Precinct Marker Signage Strategy – SSD 7317-MOD-19
Request for Additional Information

The Department has reviewed the Response to Submissions and submissions from the public and Council and requests you provide a response to the key issues identified in **Attachment 1**.

Attachment 1

Sign Locations

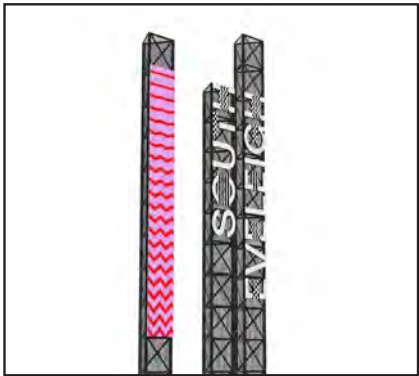
Please update the Sign Locations Plan (**Attachment A** pg 7) in the Signage Strategy to reflect the amended design for the Redfern Station sign.

Precinct Markers: Location 4

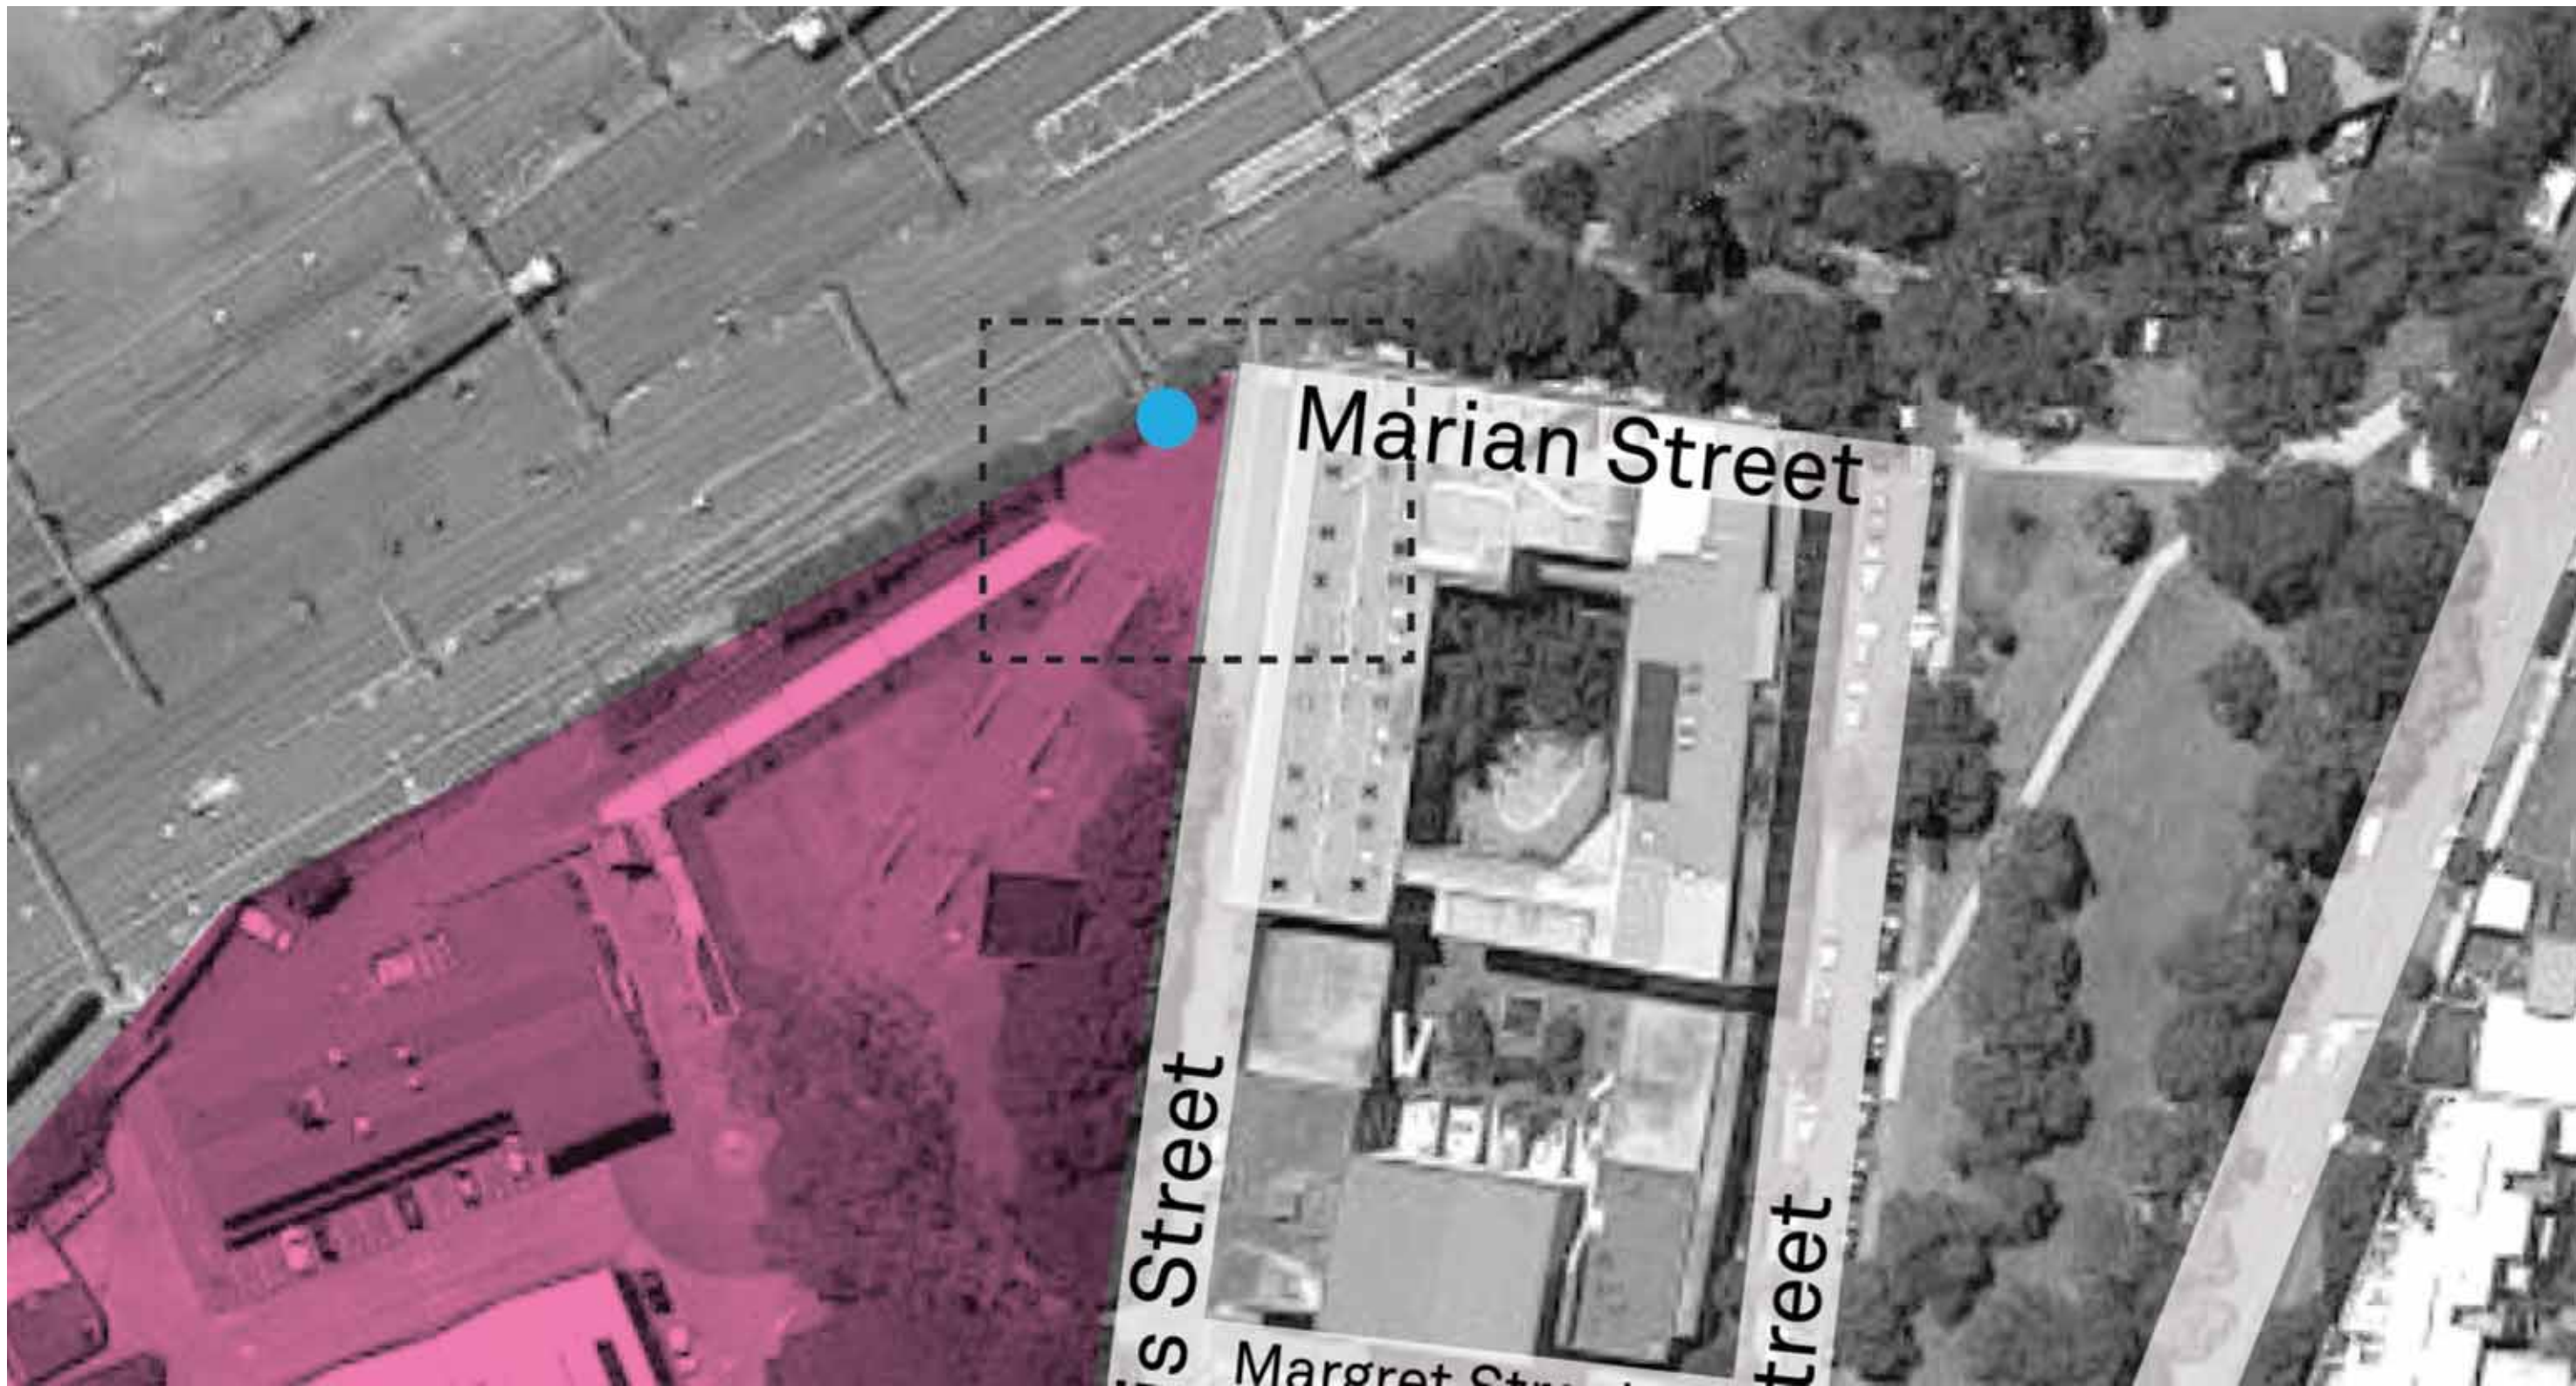
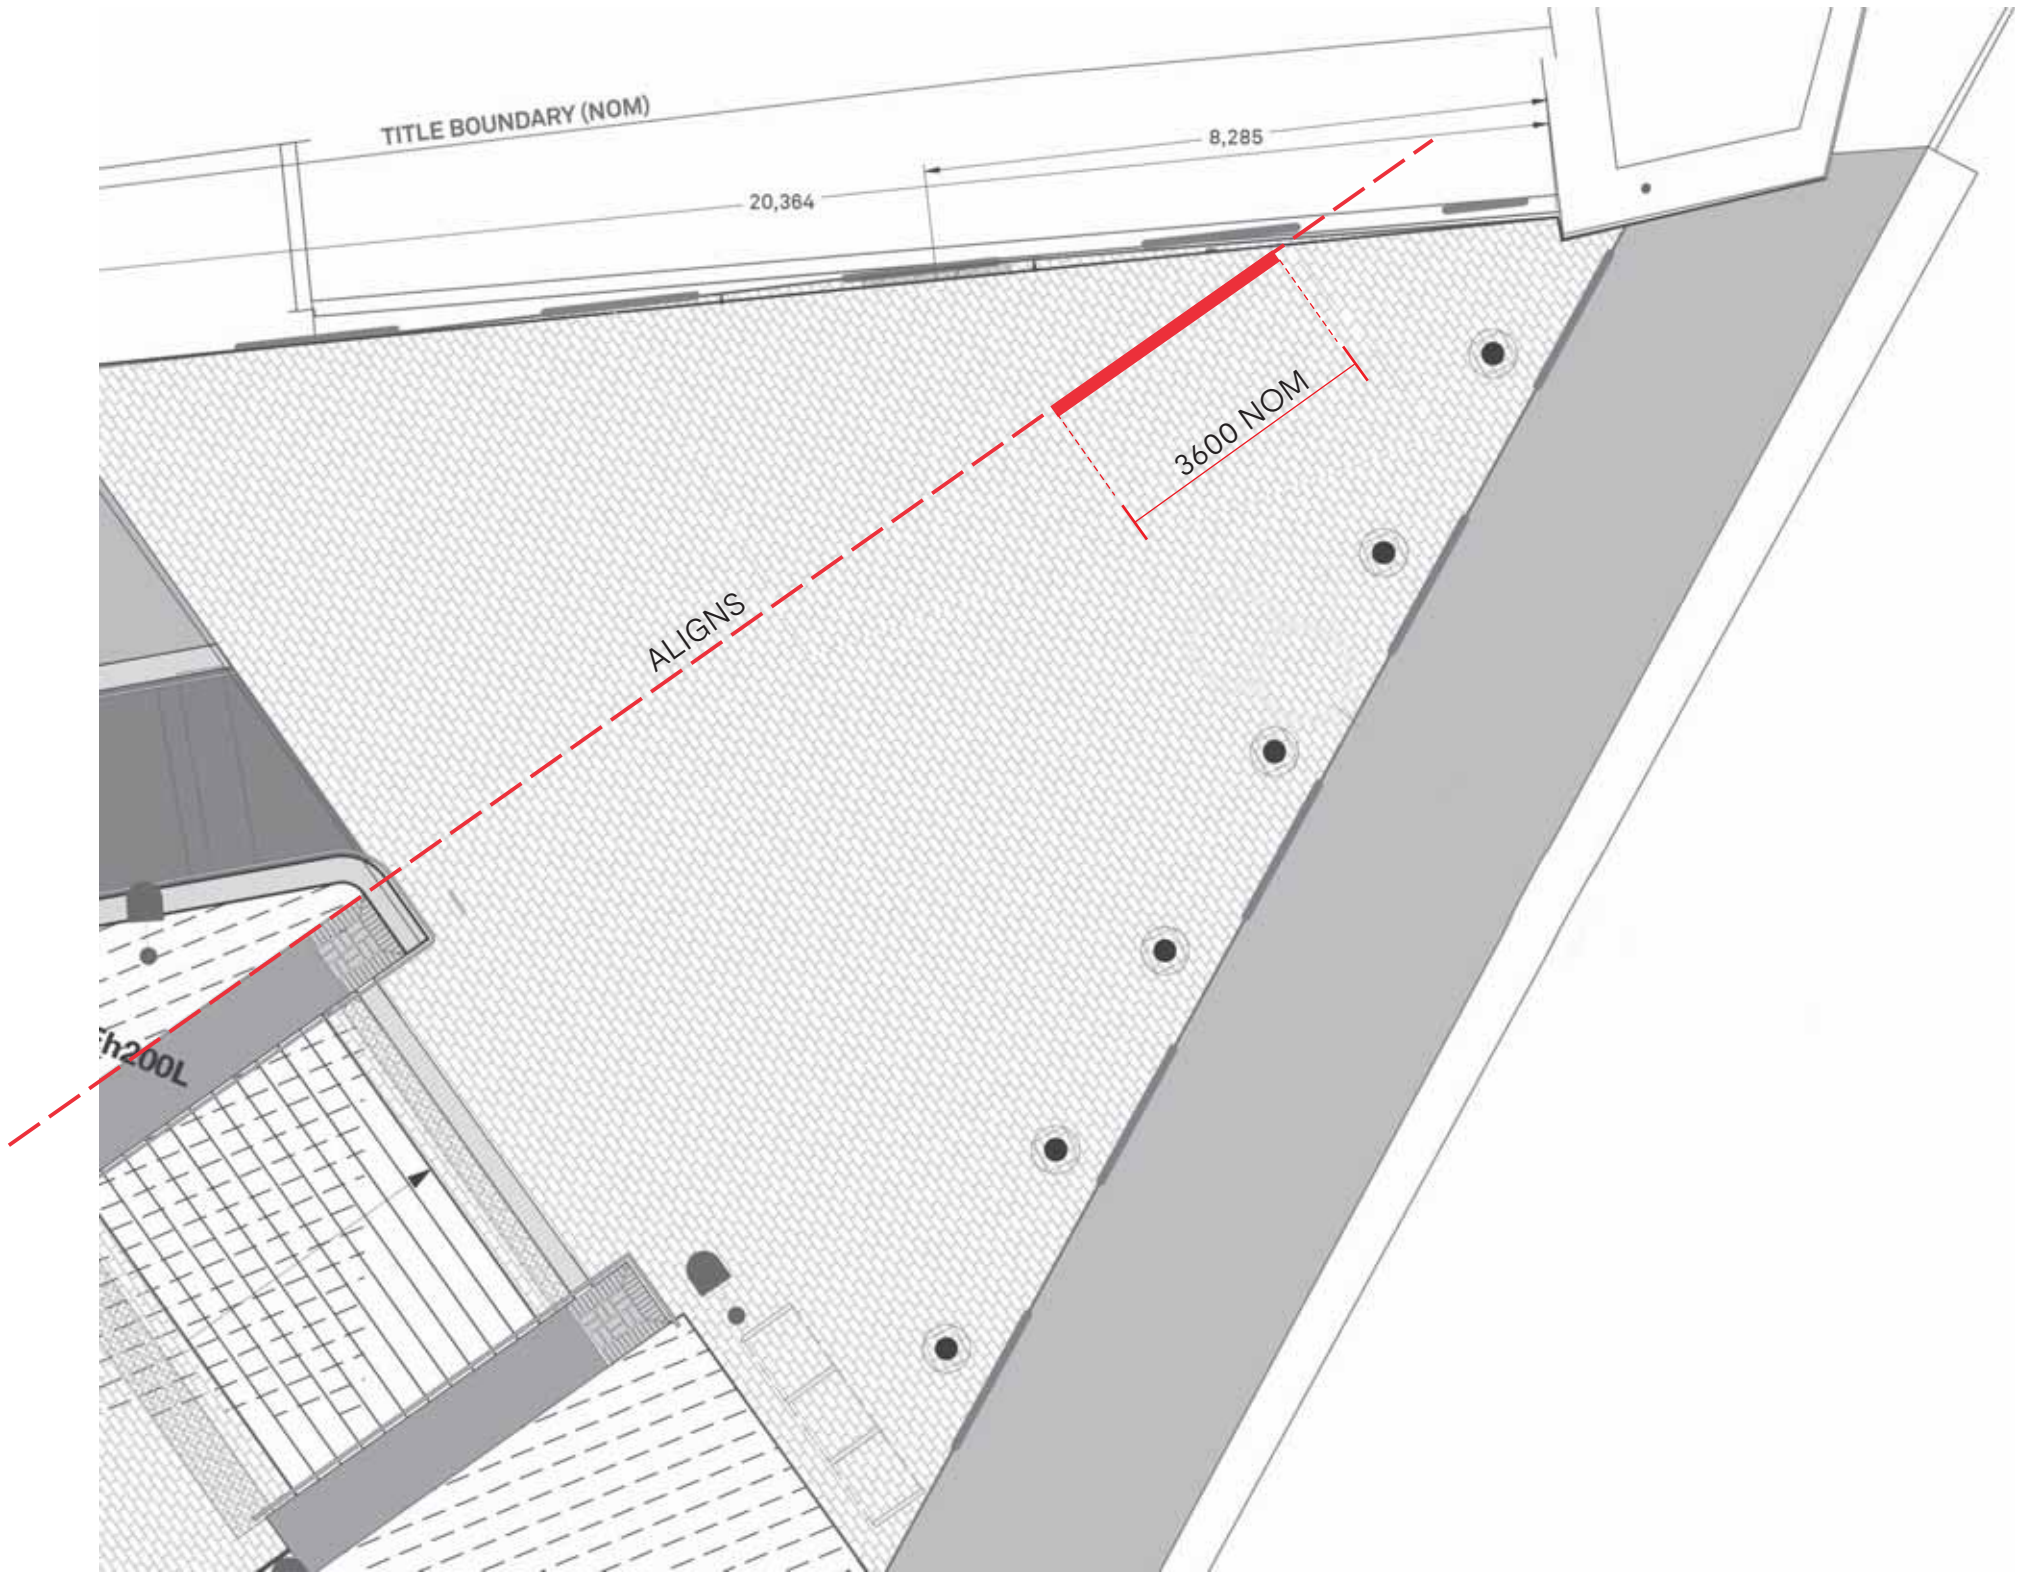
Please provide a response to Council's comments regarding the Redfern Station sign and concerns about blank areas of concealment and options to increase permeability and visibility through the sign.
